CITY OF ALBUQUERQUE

August 15, 2018

**Re: Legacy NAA Apartment
6115 Alameda Blvd NE
Request Permanent C.O. – Bldgs. 14 and 15 - Accepted
Engineer's Stamp Dated 9-15-16 (C18D073B)
Certification dated: 8-8-18**

GRADING AND DRAINAGE PLAN

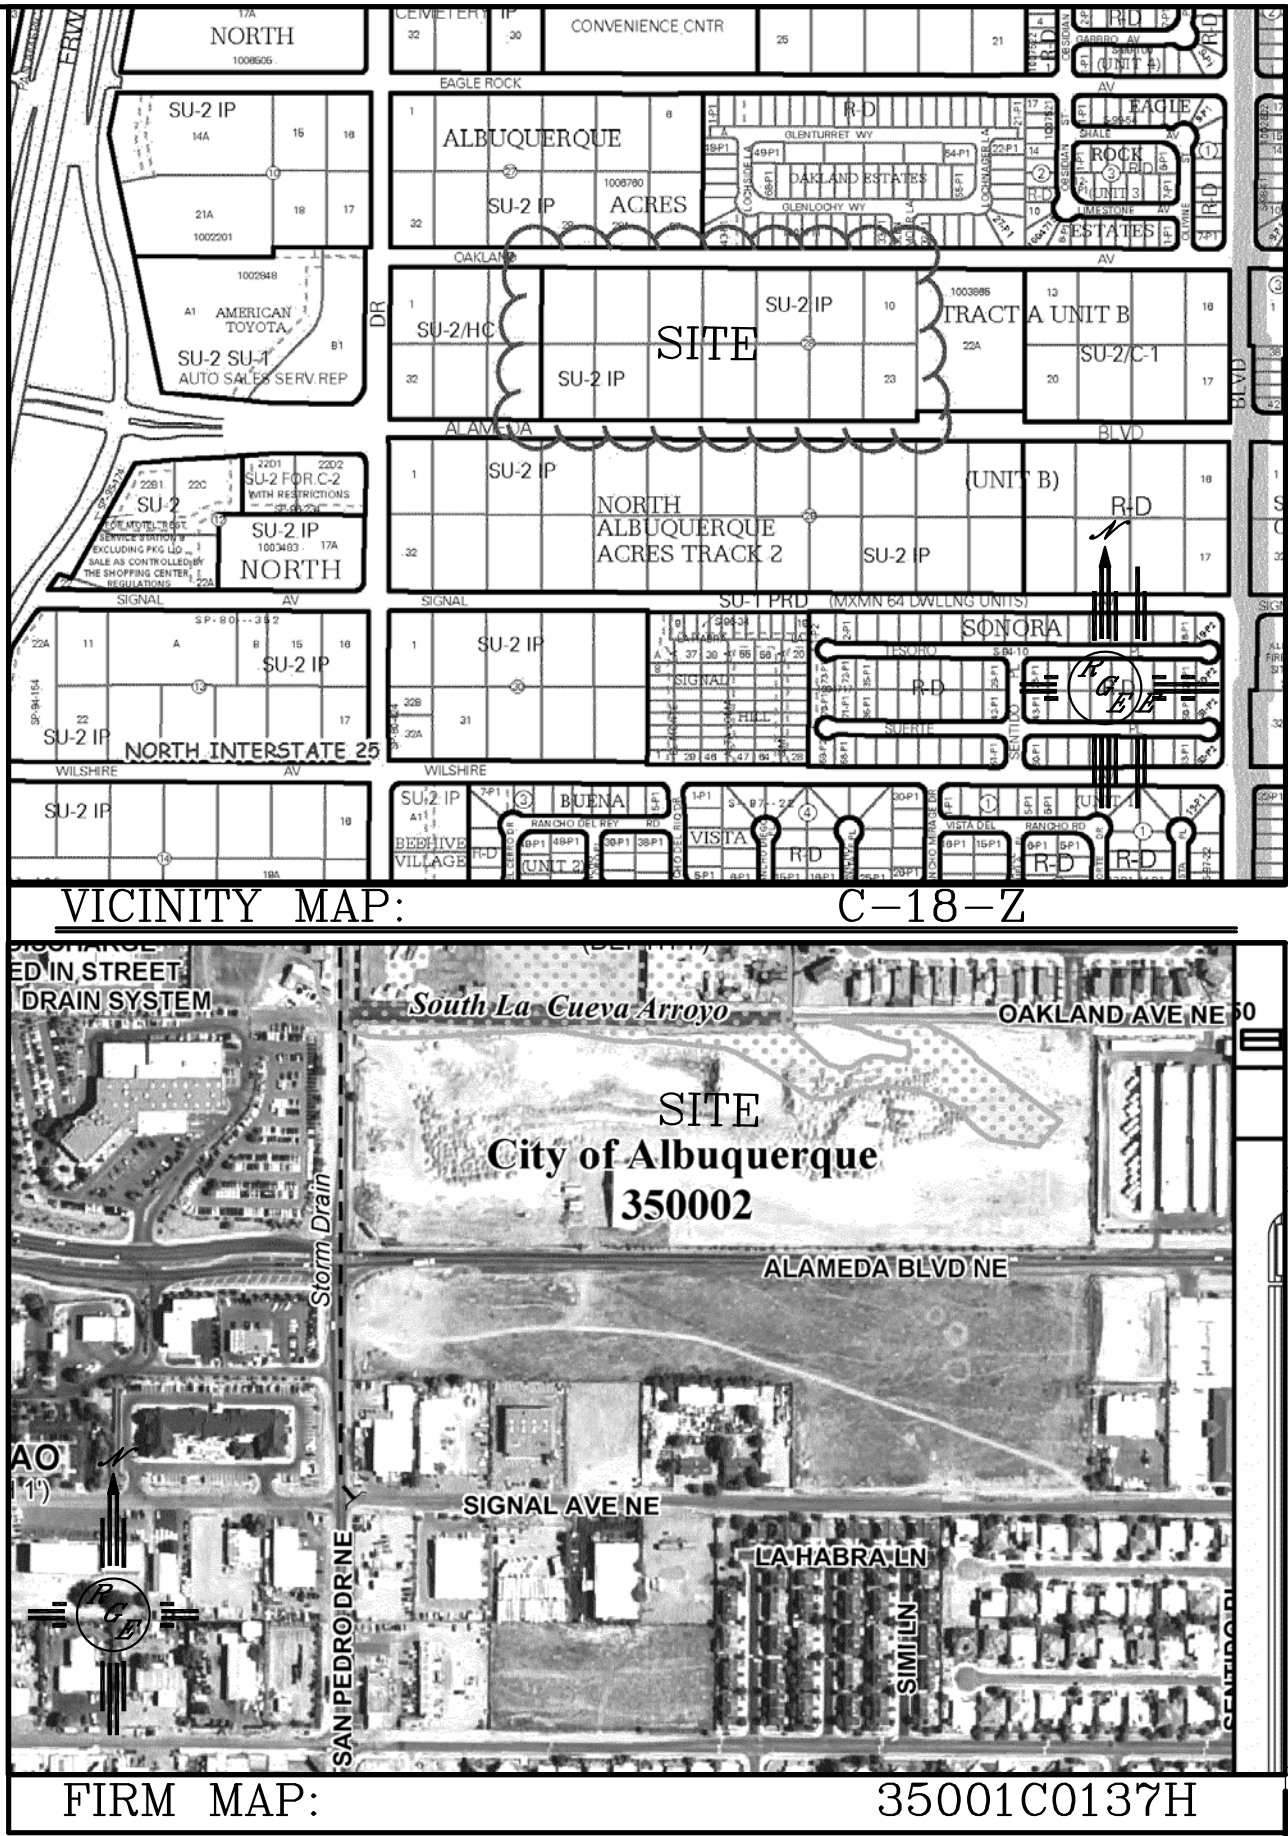
This letter serves as a "conditional approval" for building 15. The sidewalk culvert is missing that connects the 2 ponds.
